Your Ref: OWPC18274
Our Ref: M/41/18/HH 22-03-2018
Please ask for:
Zac Denton

Extension to 1st floor incorporating rooms within the roof space for new 2nd floor & single storey rear extension with balcony above.

25 Sea Way Middleton-On-Sea

PROPOSED ELEVATIONS

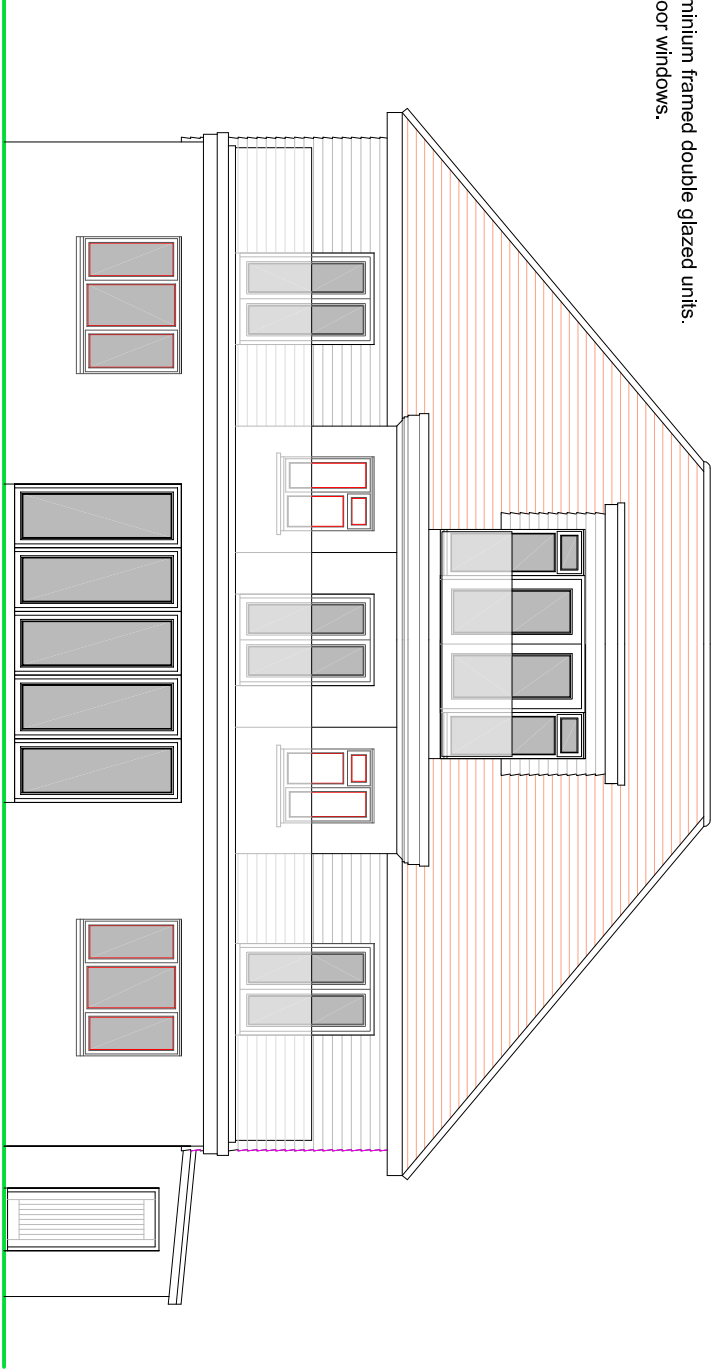
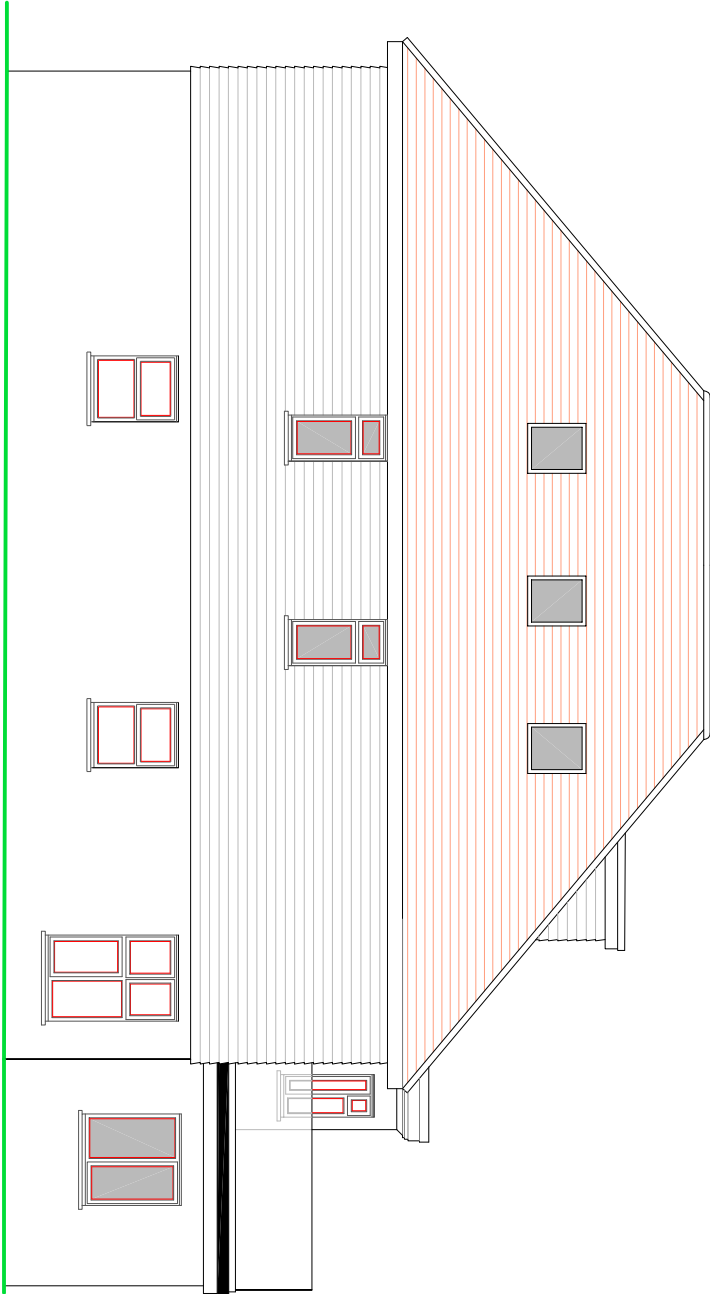
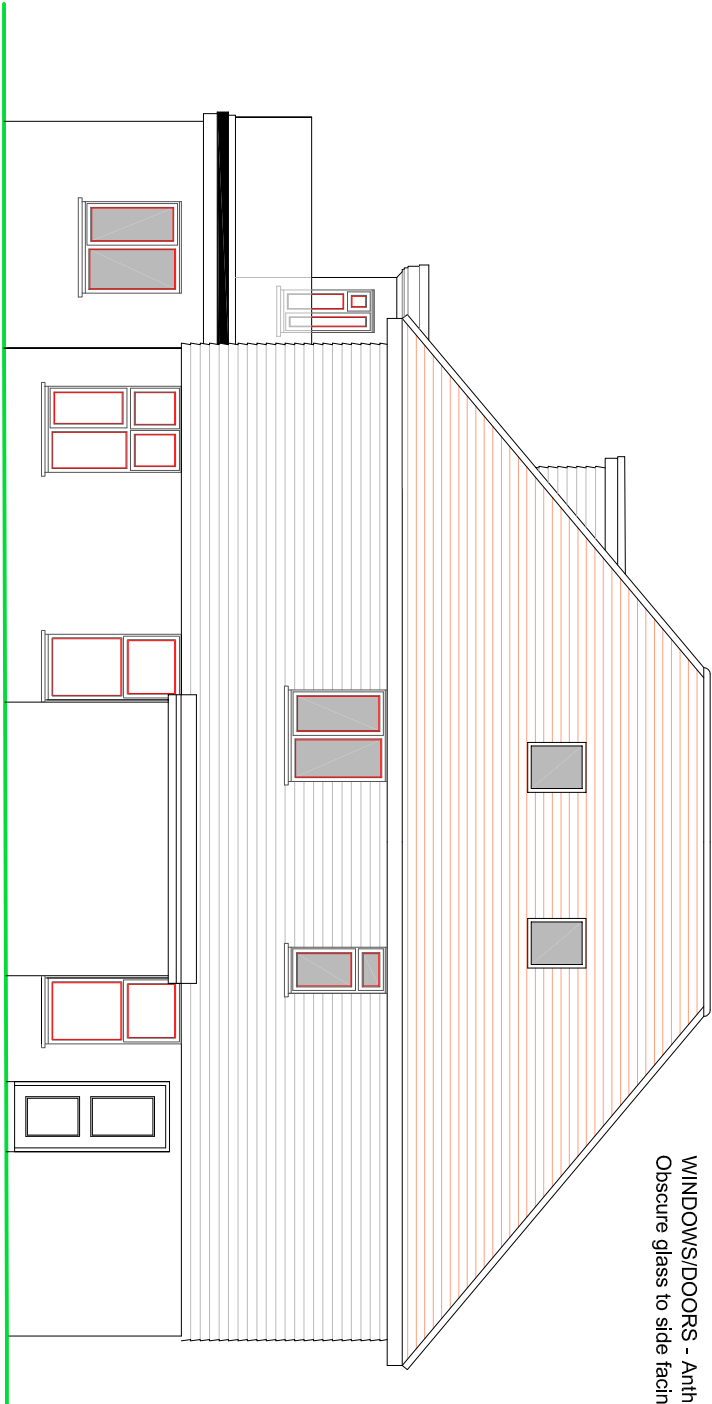
I am concerned that the third floor balcony and second floor windows are overlooking our adjoining property and therefore object on grounds of amenity for this adjoining property.
